**Date:** 14<sup>th</sup> April 2015

#### **REPRESENTATIONS: A/23/15/OUT – LAND SOUTH OF NEW ROAD AND EAST OF BROOK LANE**

**Mixed-Use Development on Land south of A259 New Road and East of Brook Lane,  
Angmering, West Sussex**

**Planning Application Number: A/23/15/OUT**

Title
HIGHWAY ACCESS PLAN

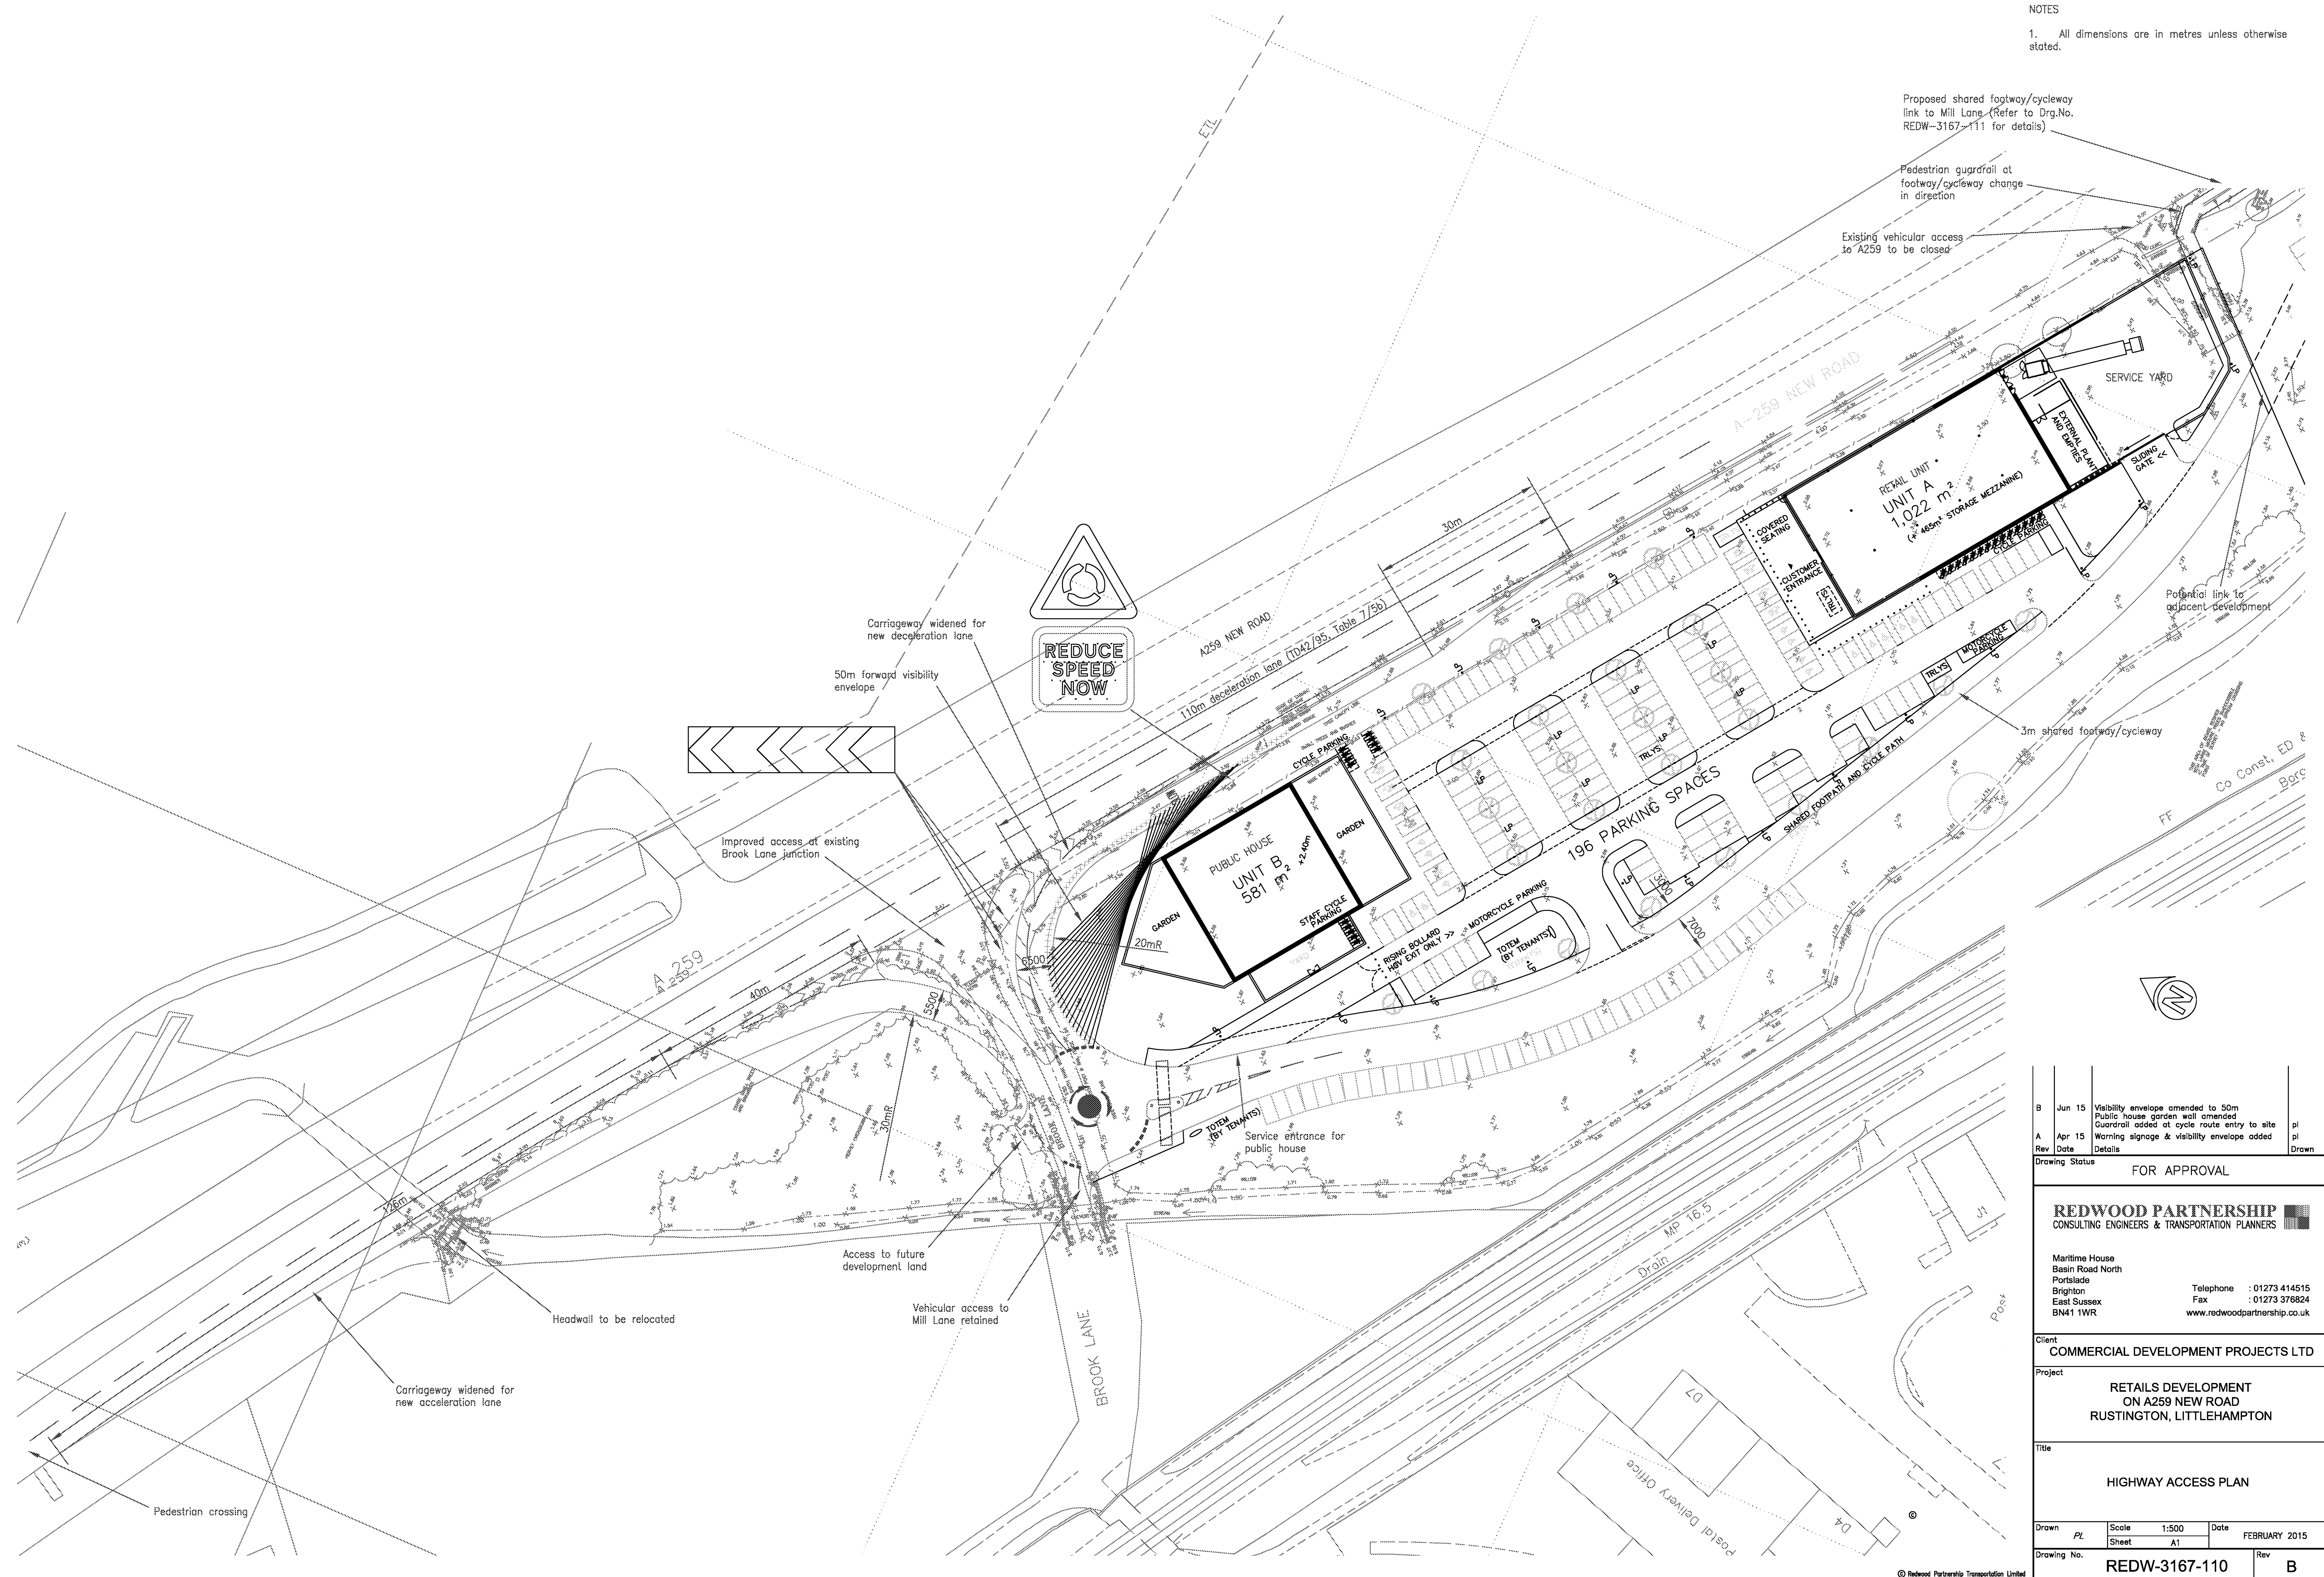
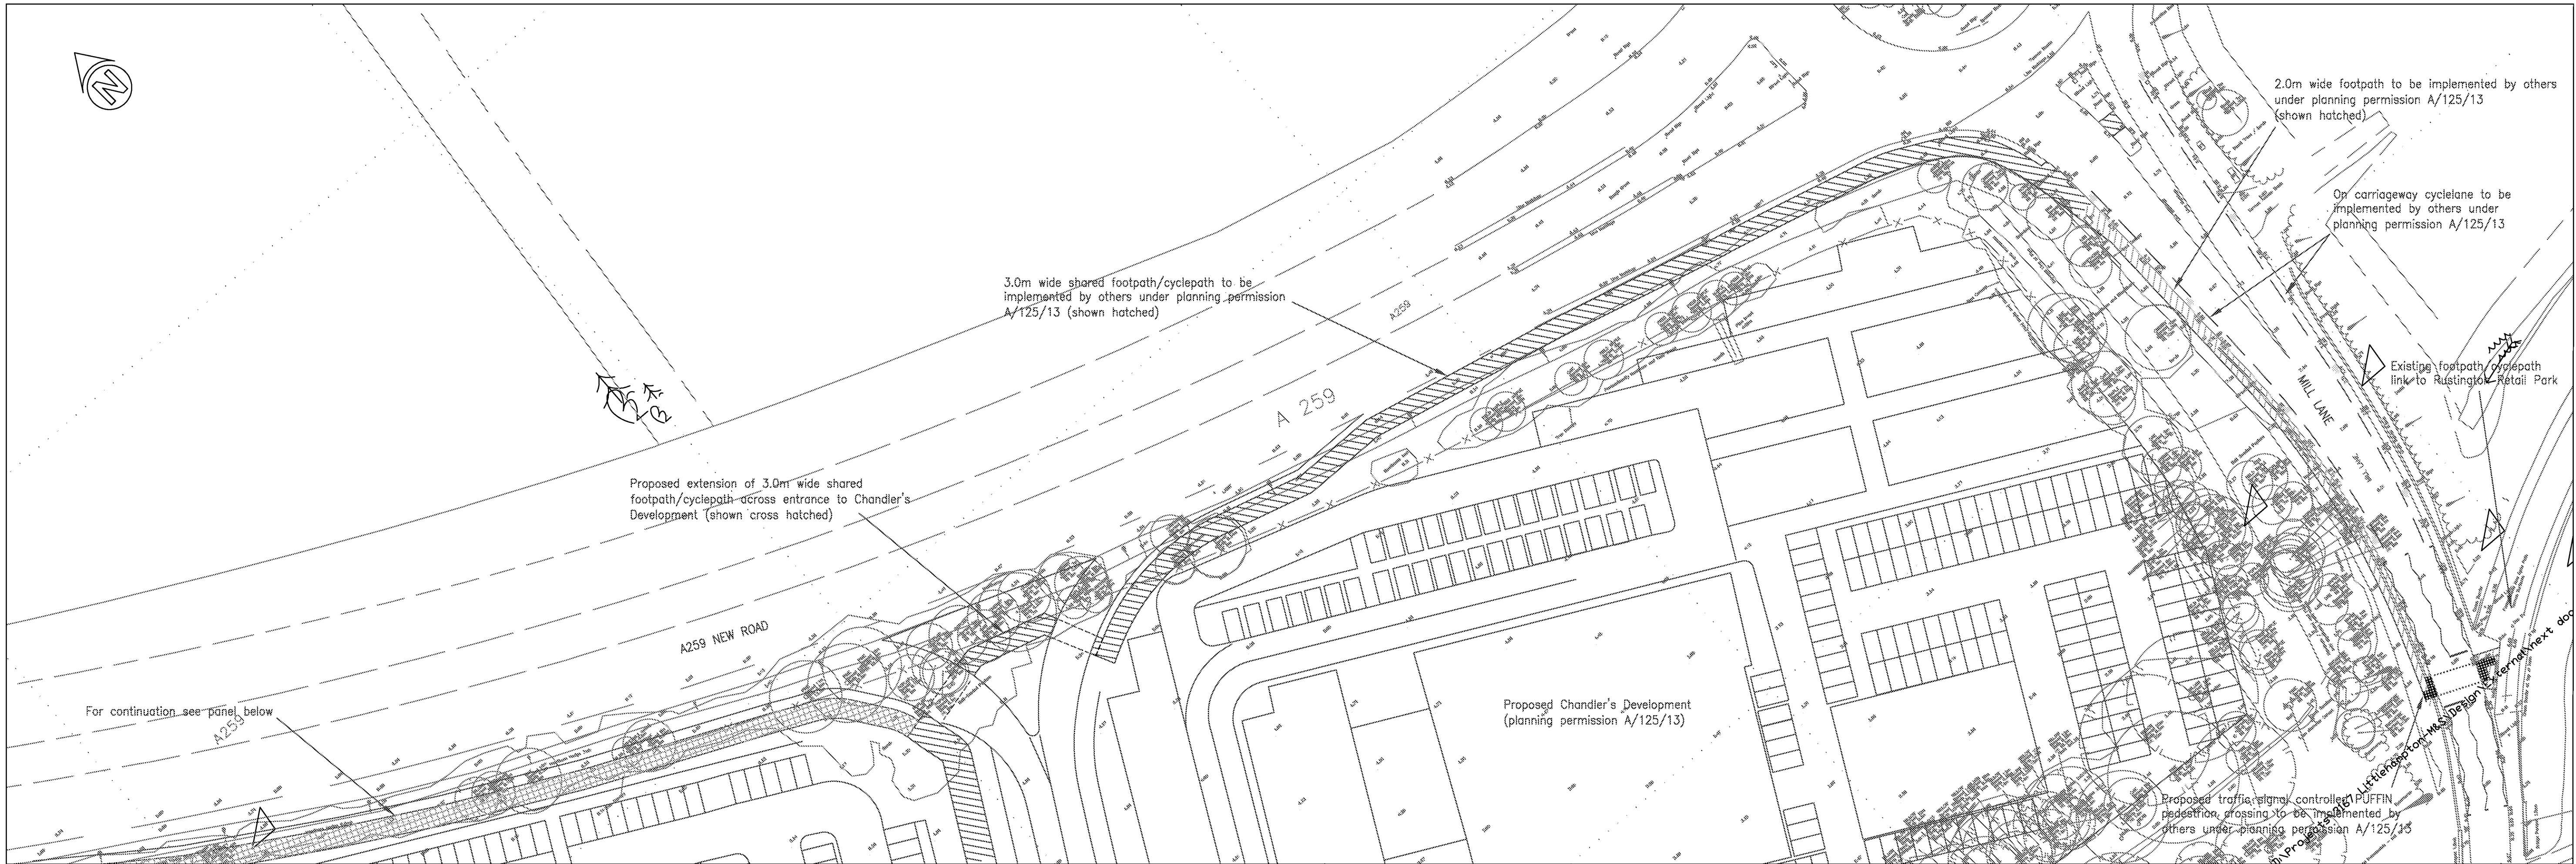
The proposed access from the A259 does not comply with the Department of Transport (DfT) design standards. The entry radius (radius from the deceleration lane to the proposed roundabout) is shown at 20m, which is significantly below the appropriate standard. The DfT design standard DMRB TD42/95 states that for a design speed of 120kph (70mph) a minimum radius of 40m is required. To put this in context, the proposed 20m radius is only suitable for roads where the speed is below 40mph. Traffic speeds along this section of the A259 are not restricted. The Transport Assessment (TA) submitted in support of the application states that the

traffic speed survey recorded a 67mph 85th percentile speed at the Brook Lane junction.

In our opinion the proposed mini-roundabout, which has a diameter of approximately 21m, is too small to satisfactorily accommodate four arms. The roundabout as shown is too small to provide appropriate radii and separation between arms of the junction. In particular, the accesses to Brook Lane and the land to the west are very small and appear to have been squeezed to fit in.

Brook Lane is currently a narrow access road which benefits from a straight alignment. The proposed roundabout would require vehicles to approach Brook Lane at an angle which is likely to be difficult for larger vehicles. Due to the restricted width of Brook Lane vehicles need to approach it as straight as possible. A larger vehicle would therefore be required to drive straight across the roundabout rather than navigate around the roundabout.

BASE TRAFFIC FRIDAY PM PEAK HOUR 1645-1745HRS WITH TRAFFIC GROWTH TO YEAR OF OPENING 2016

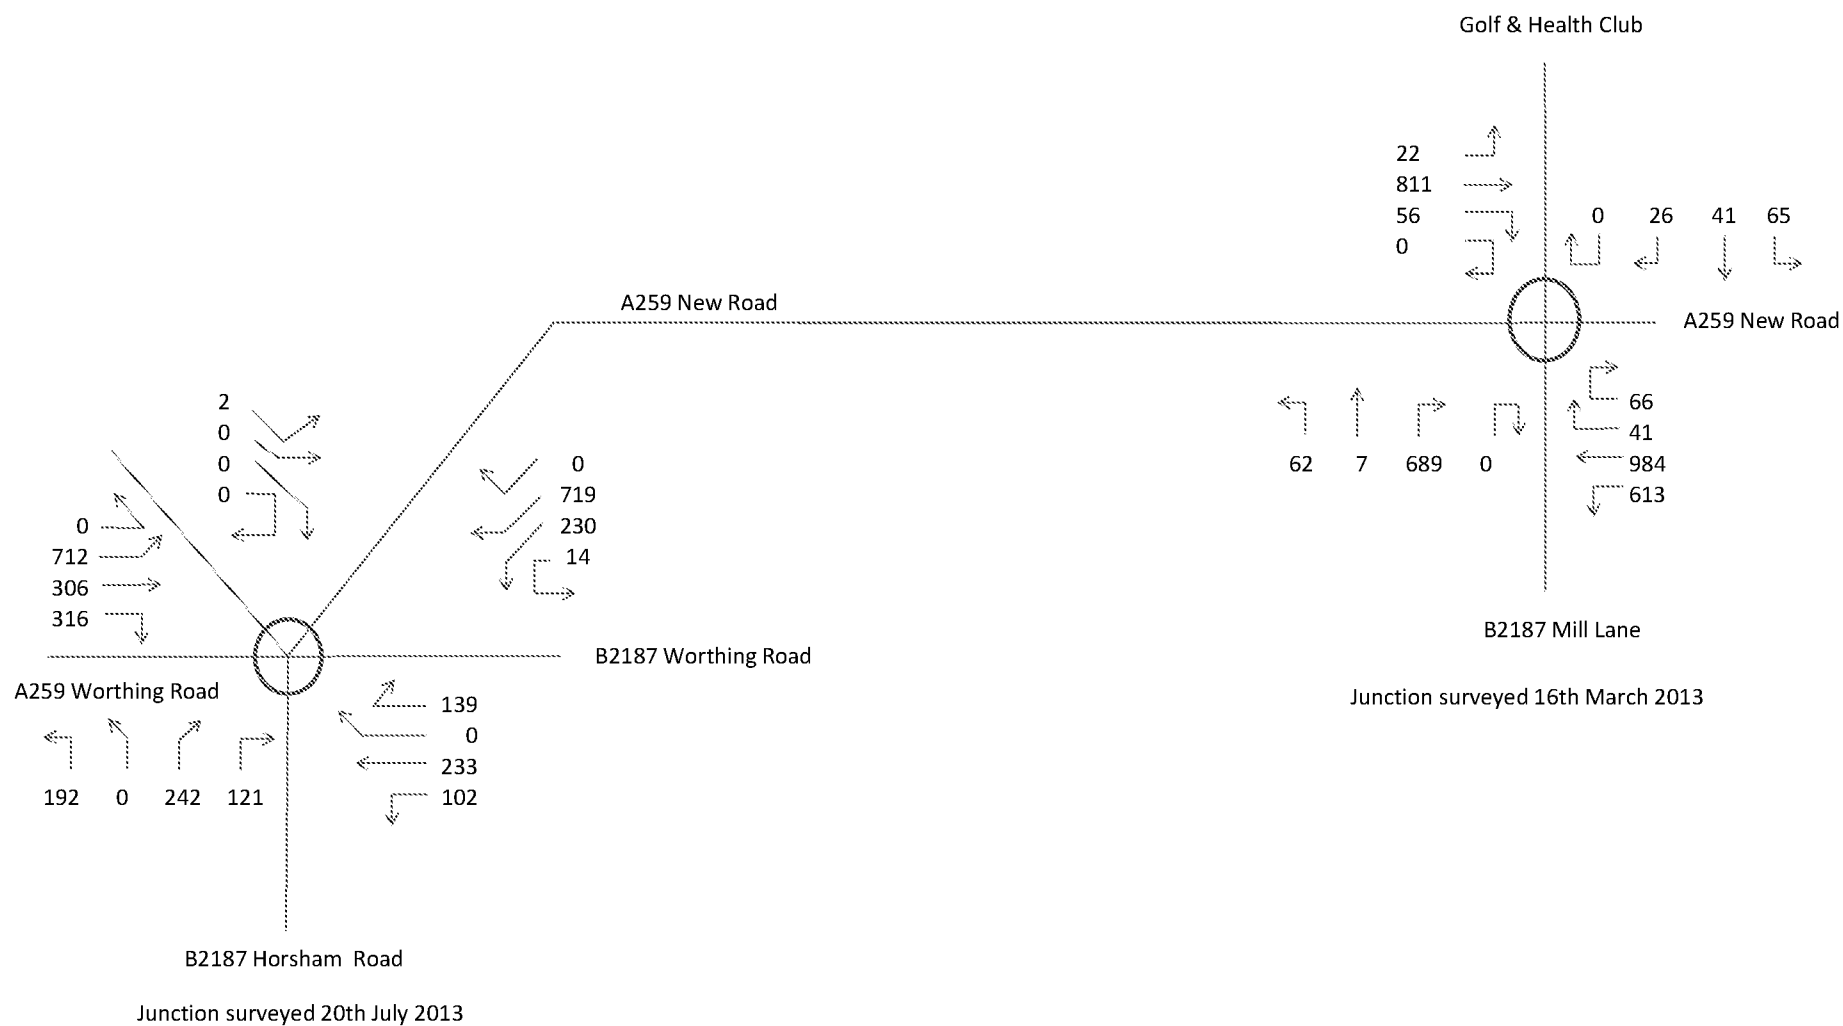
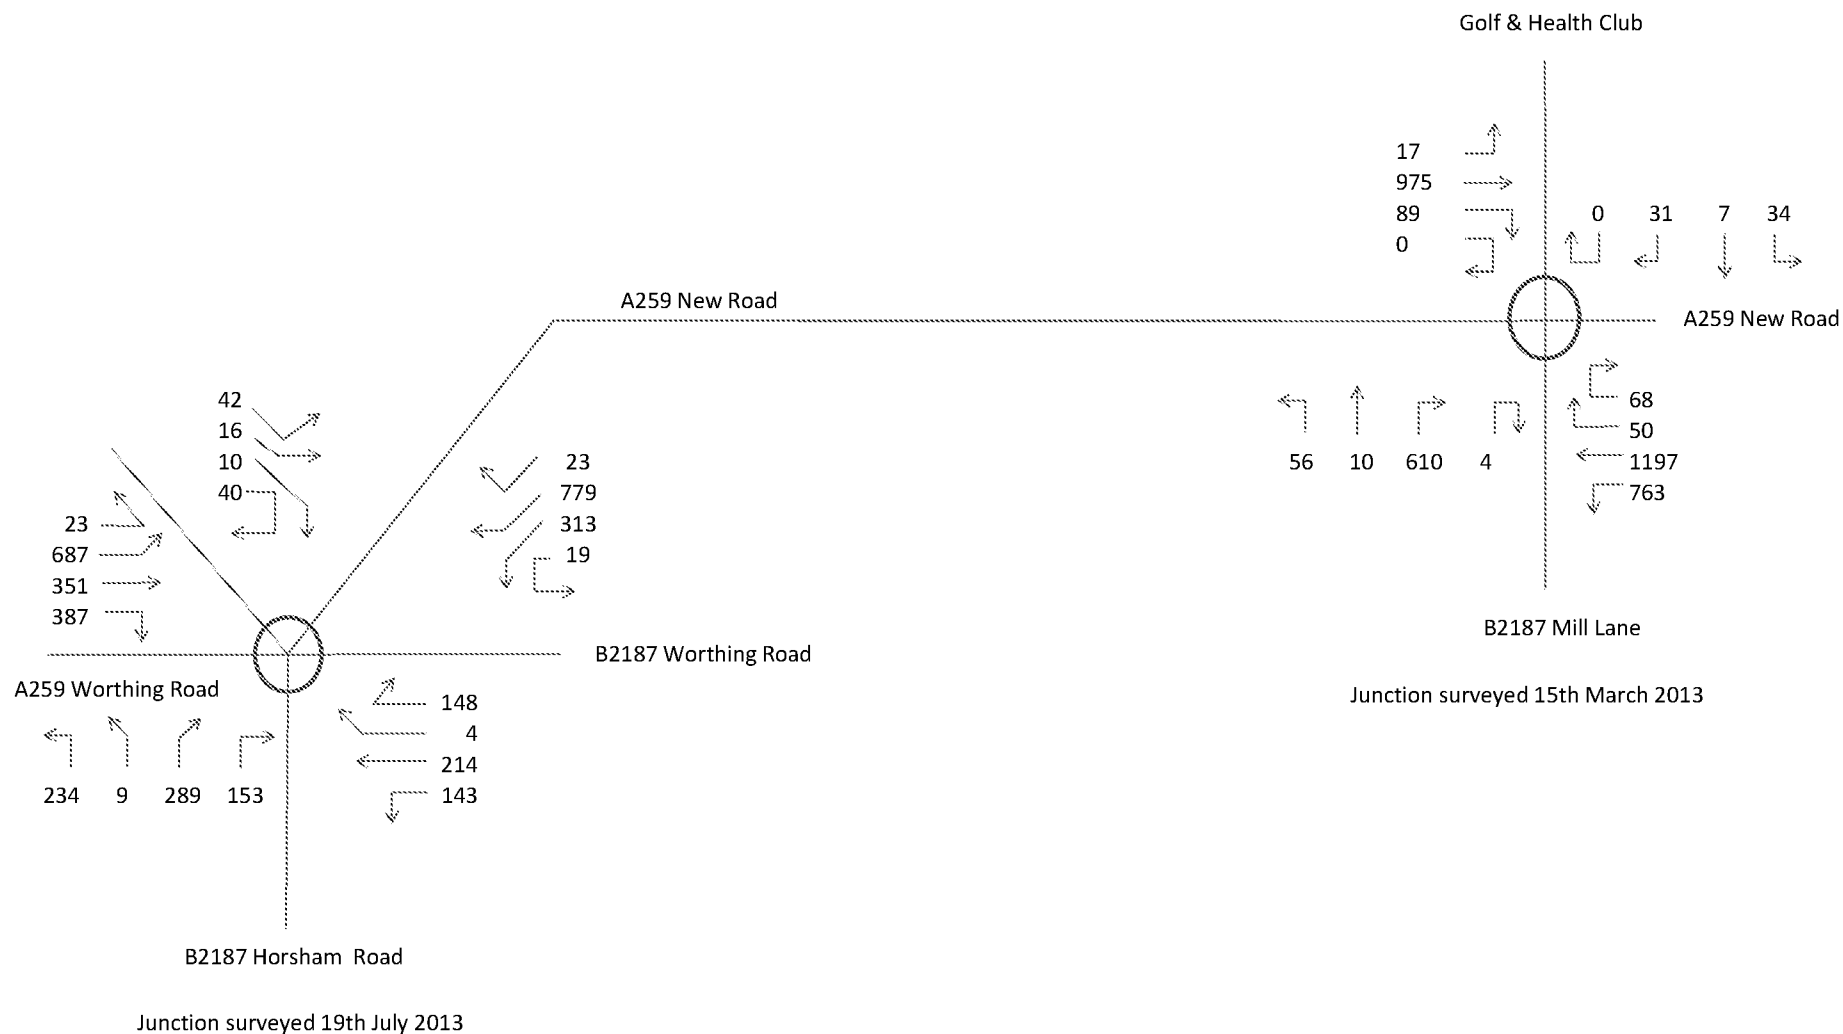
It is also noted that the growth figures shown at Table 4.1 are incorrect as traffic growth to 2016 will not be the same as growth to 2020.
